Subject: **Request for Modification to Individual Section 404 and Section 401 Water Quality Certification** for the Winston-Salem Northern Beltway from US 52 to US 311 (New Walkertown Road), Forsyth County. Federal Aid Project No. NHP-0074(213), TIP Nos. U-2579D, E& F. Division 9.

The North Carolina Department of Transportation (NCDOT) requests modification to the existing Section 404 Individual Permit and Section 401 Water Quality Certification for the proposed Winston Salem Northern Beltway from US 52 to US 311 (TIP U-2759 D, E, and F) in Forsyth County. This project is currently under construction.

Permit Impact Site Modifications

**LEGEND:**

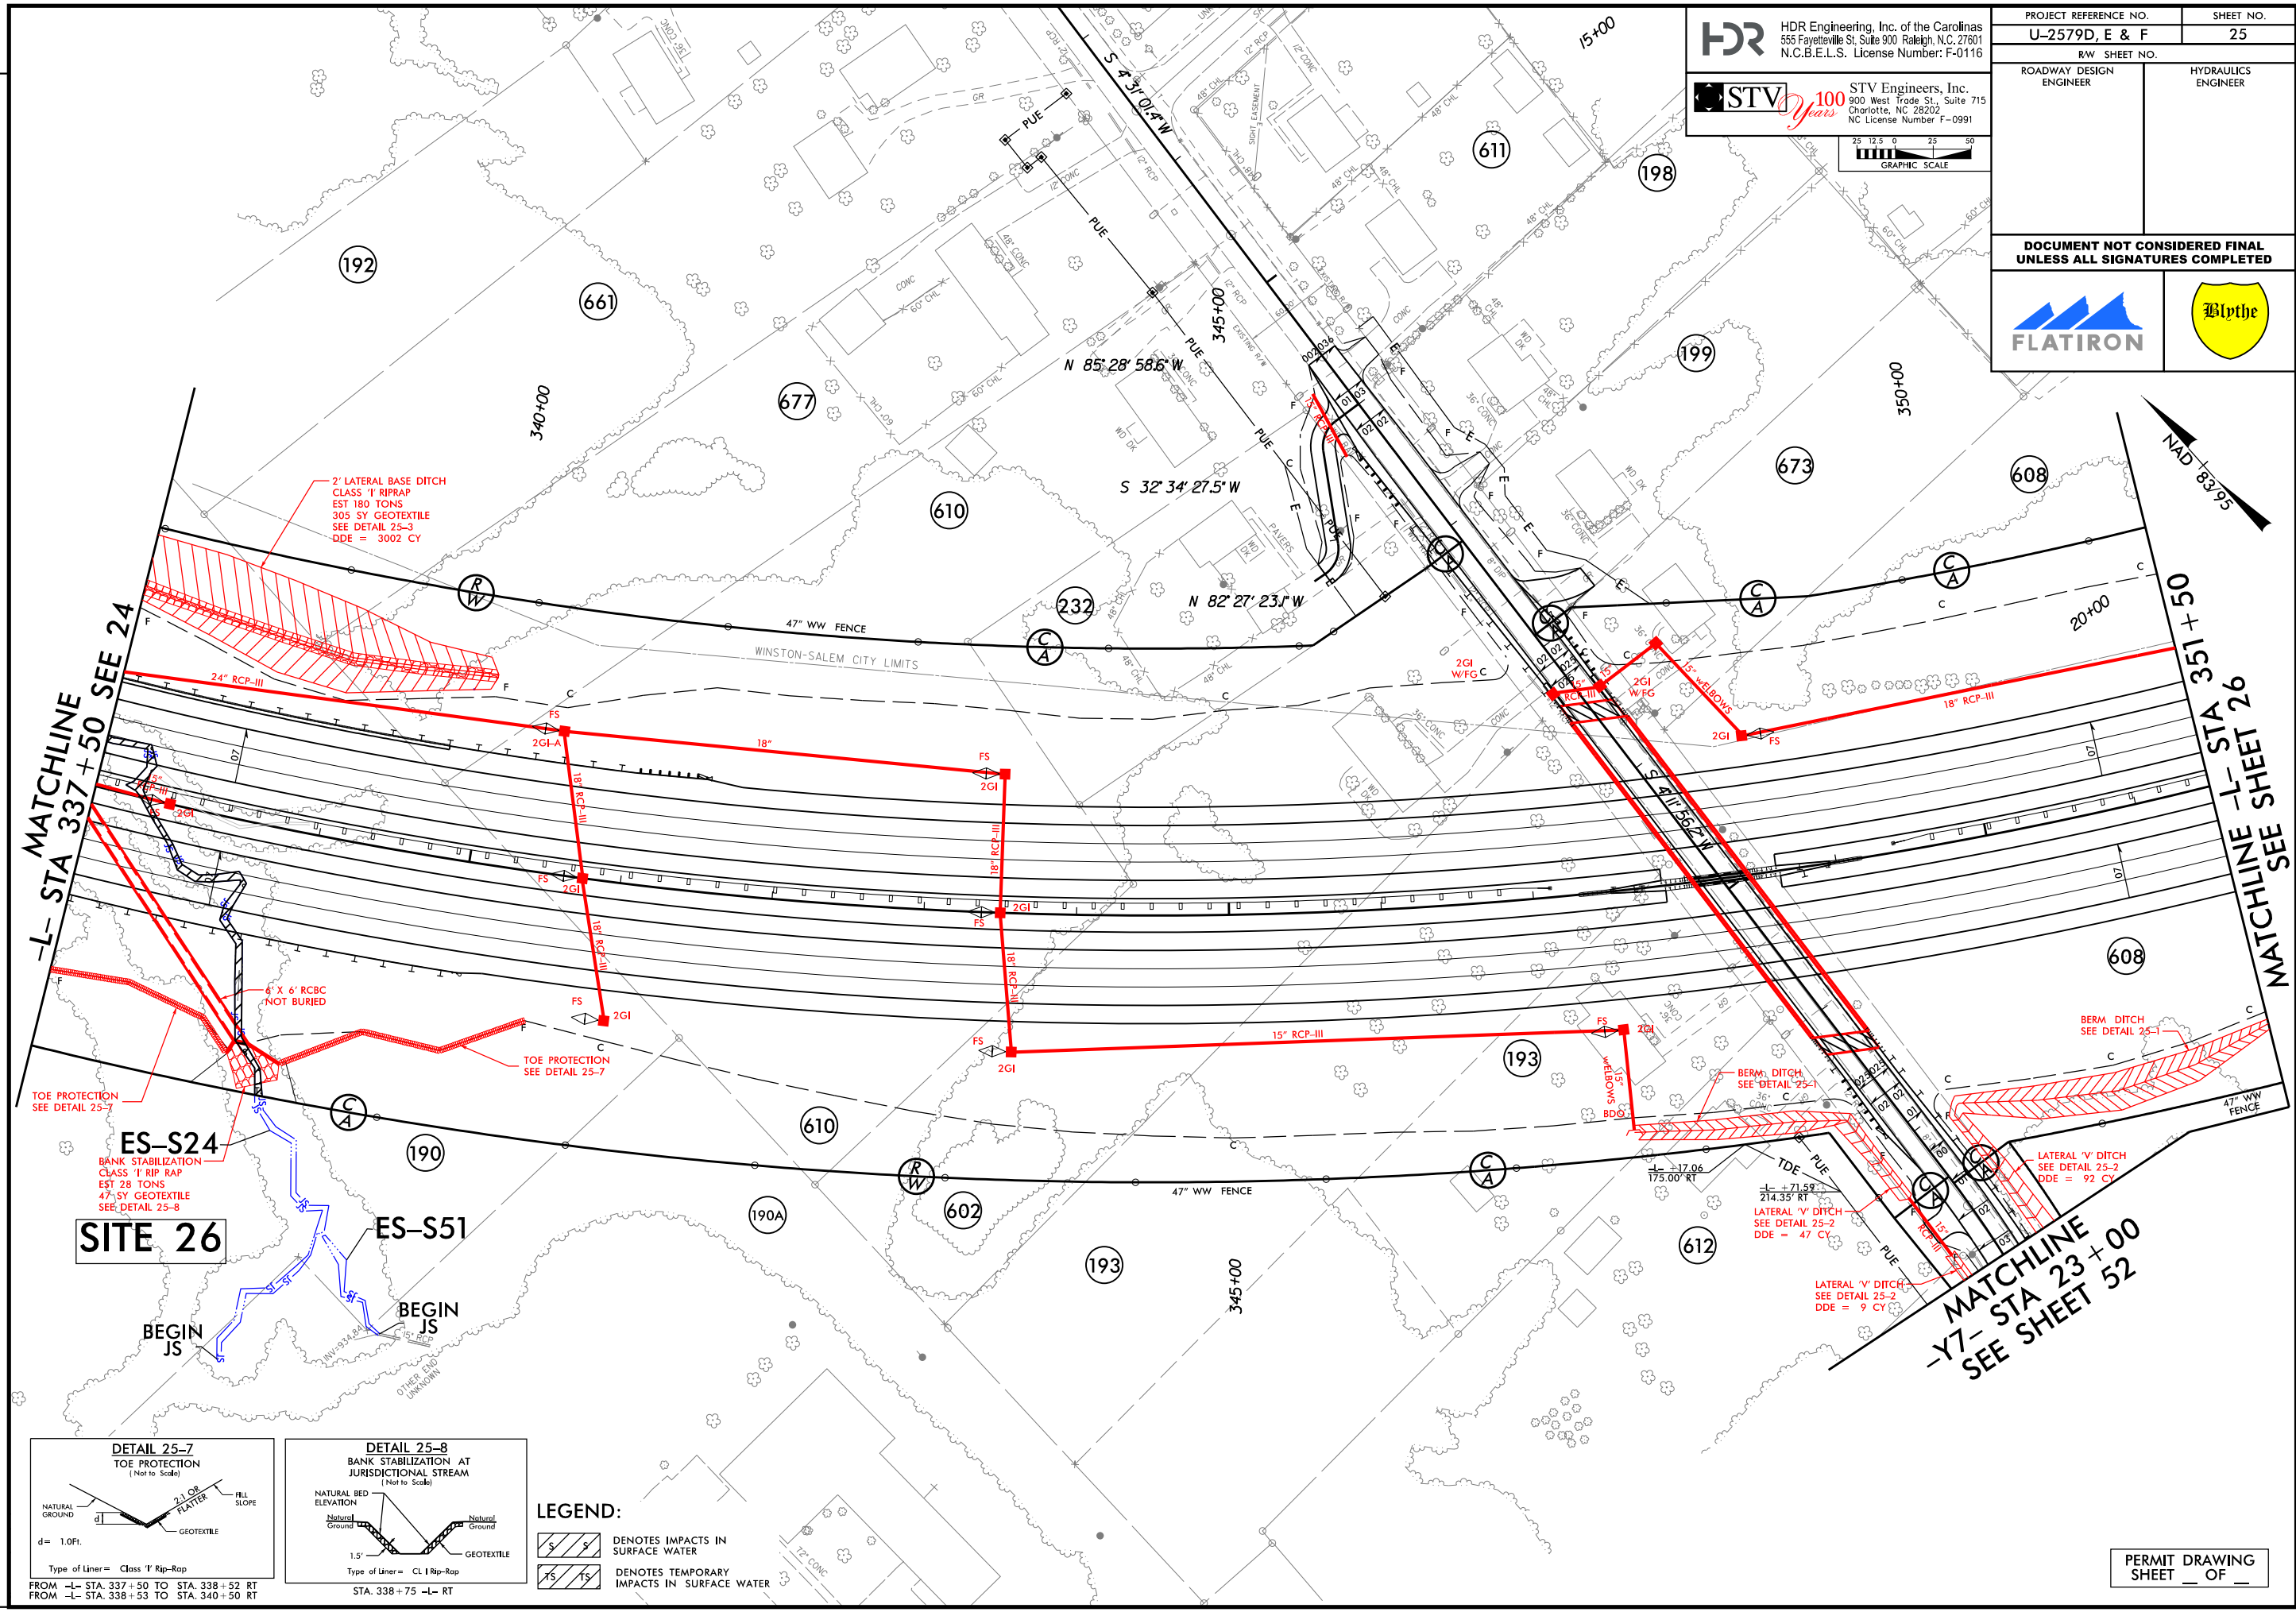
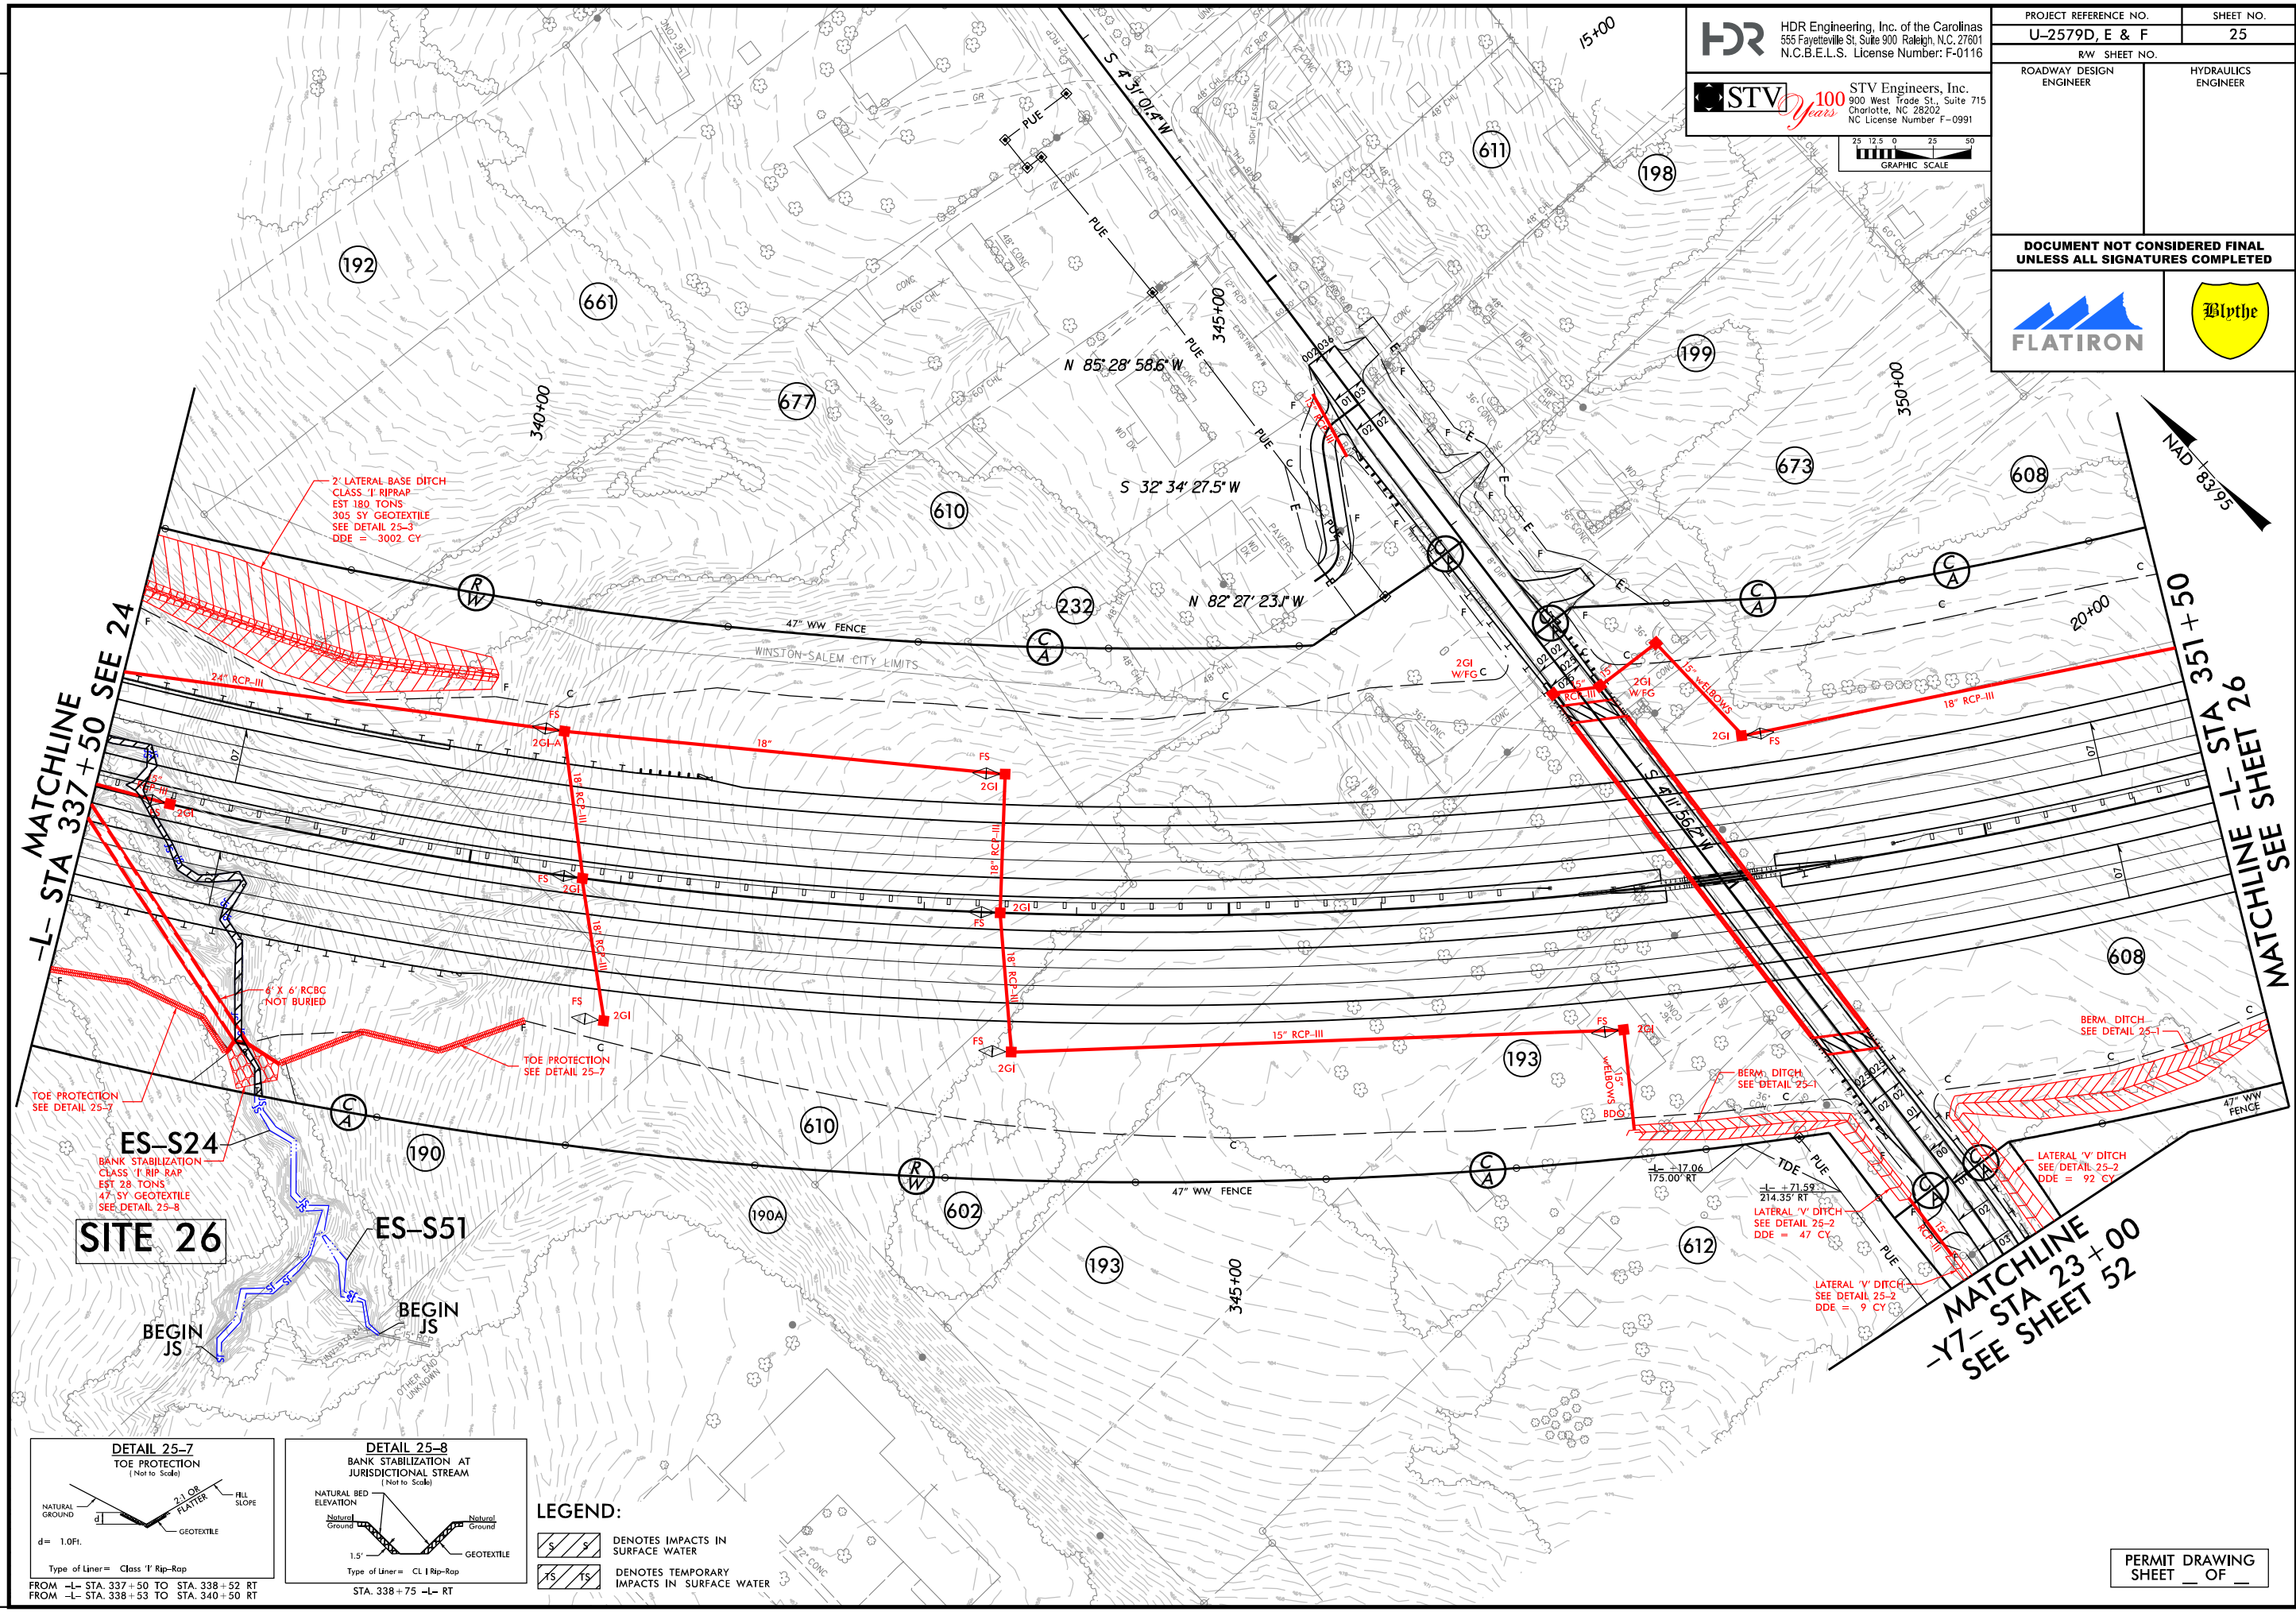
Site 26 (Sheets 24 and 25): Site 26 impacts changed as a result of the final design of the 6x6 RCBC in which the culvert length was increased from preliminary plans. When reviewed with the previous modification the new culvert length resulted an increase in permanent impacts by 4 linear feet for the RCBC and by 5 linear feet for bank stabilization. The temporary impact at this site was reduced by 2 linear feet. There will be a total of 523 linear feet of impact due to the RCBC, 29 linear feet of bank stabilization, and 18 linear feet of temporary stream impact at Site 26.
